RIO GRANDE ENGINEERING OF NEW MEXICO, LLC

**RE: Preliminary Plan/Site plan - Quivira  
PR-2020-004457  
Tract 22 and Quivira Drive Volcano Cliffs Unit 6**

The purpose of this letter is to accompany the revised plans and explain how the comments were addressed

| ENGINEER'S SEAL DAVID SOULE P.E. #14522 | QUIVIRA ESTATES SITE PLAN FOR BUILDING PERMIT | DRAWN BY WCWJ DATE 8-21-21 2102059-LAYOUT-9-06-20 |

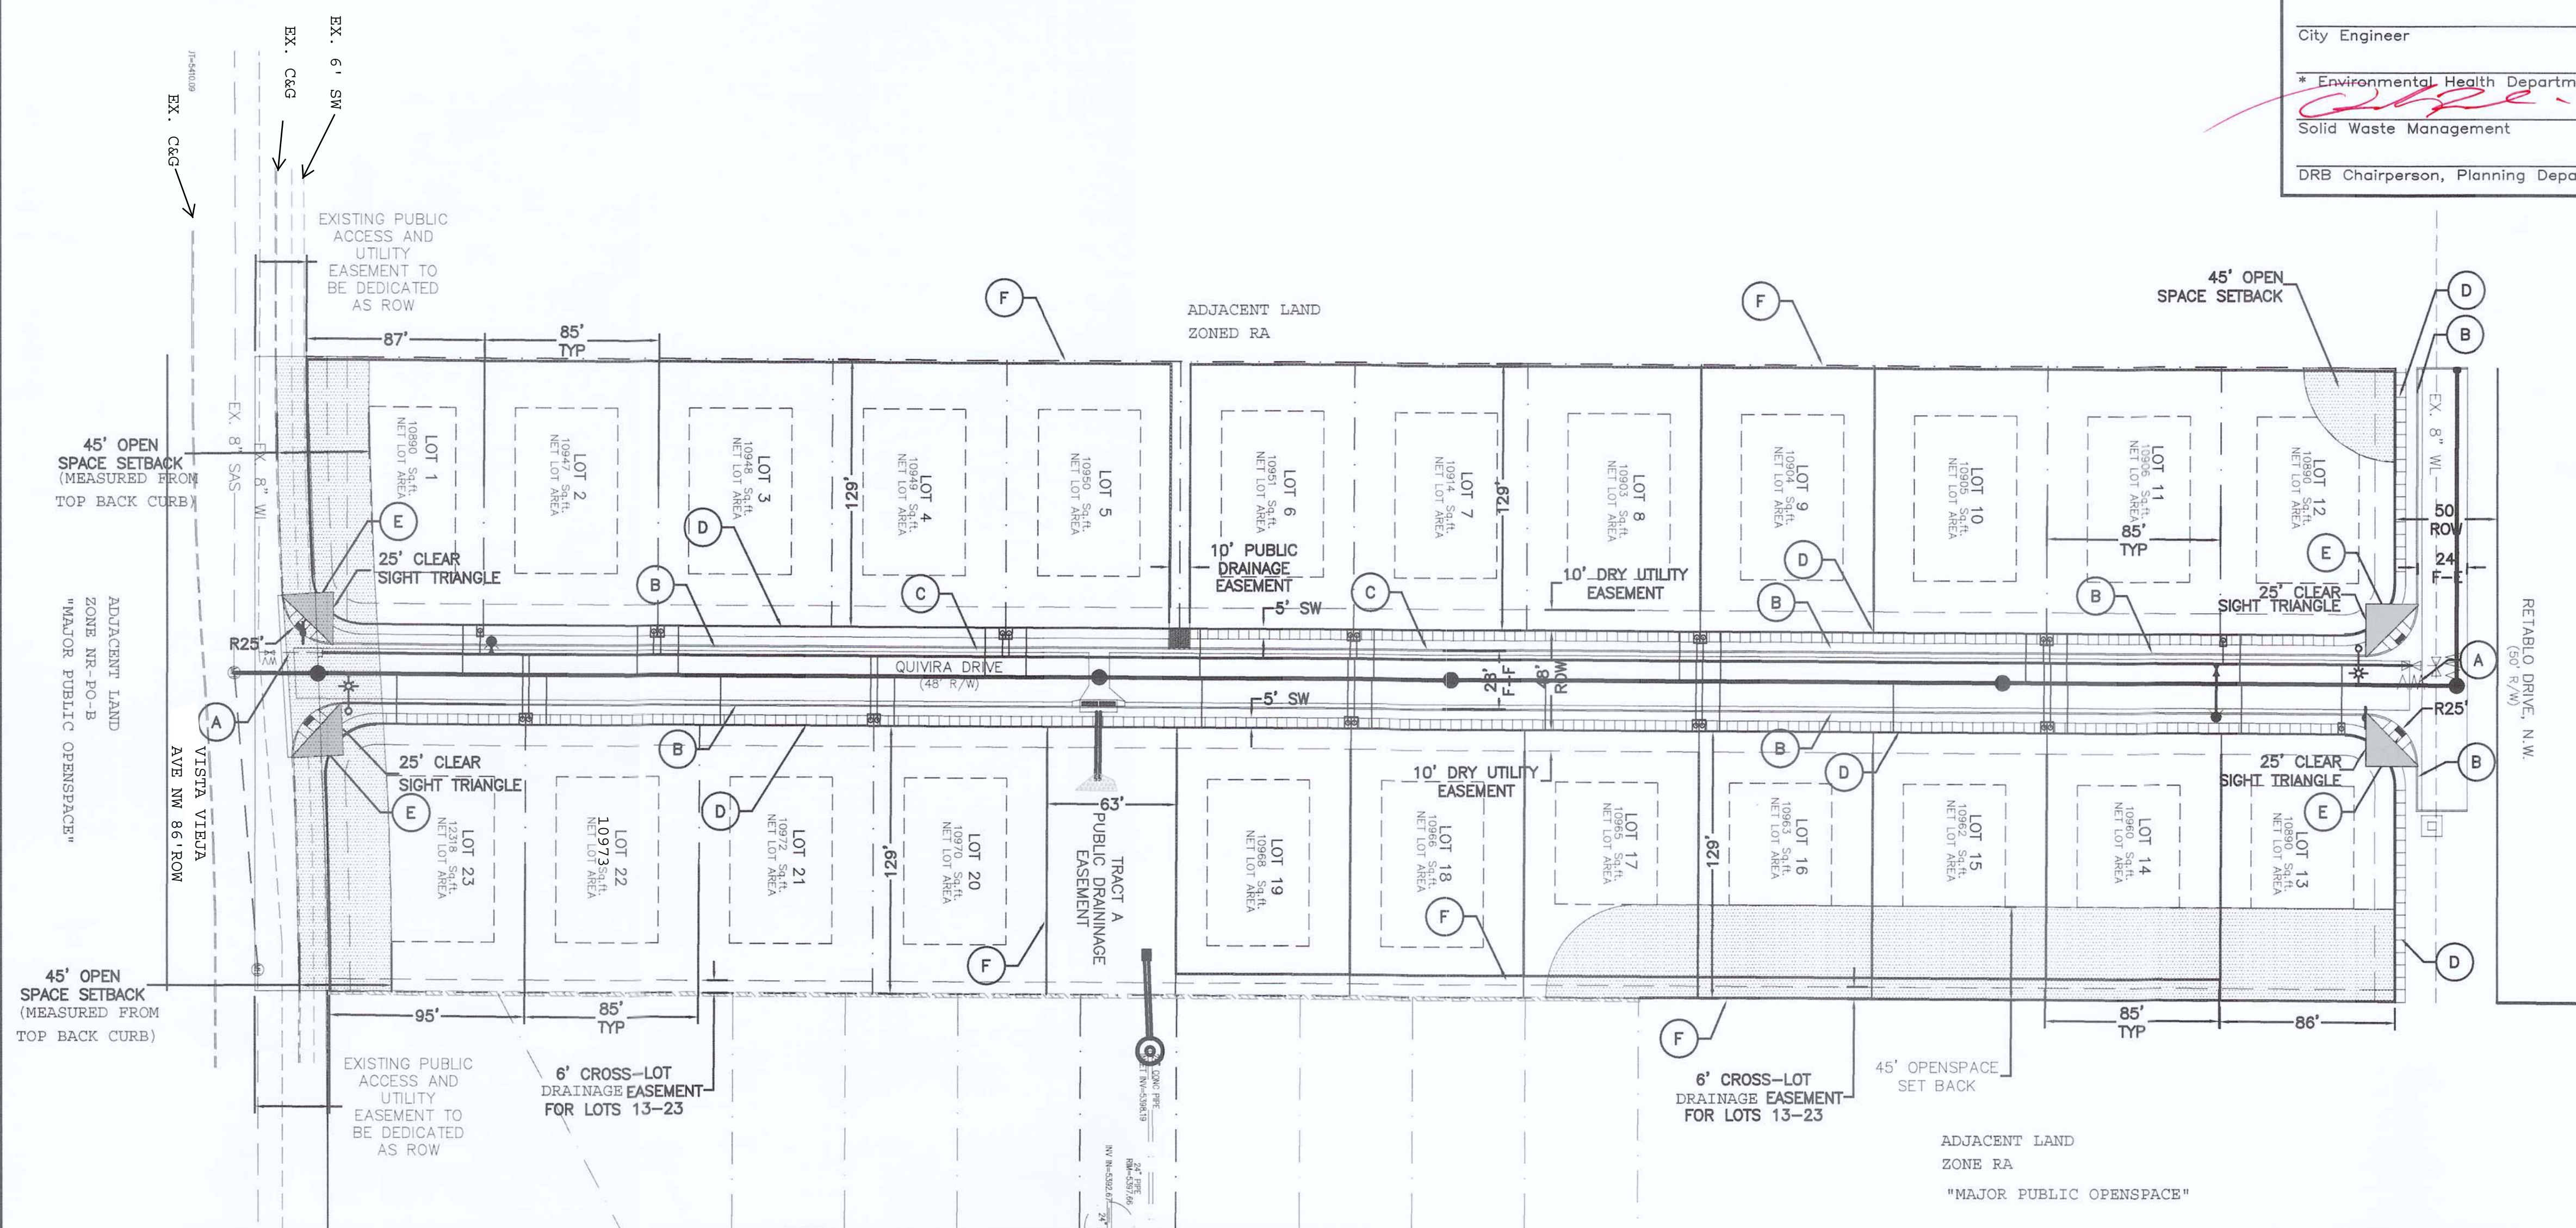
1. Transportation-
  - A. We have labeled sidewalk on Vista Vieja
  - B. We have included street lighting at both intersections on the infrastructure list.
  - C. We have corrected name of southern street to Vista Vieja
2. ABCWUA-
  - A. We are hoping the development agreement is signed by ABCWUA, not in our control
  - B. We desire to pay prorata at time of approval, it is our intent to have this delegated to ABCWUA so we can pay the fee once we have approval and delegation
3. Code Enforcement
  - A. General Note #5 was changed to state development to conform to 2019 IDO
  - B. lights revised to be 16/
  - C. Other comments relate to 2020 IDO, so not modified.
4. Planning/Parks
  - A. We provided exhibit as to how the 45' setback modified
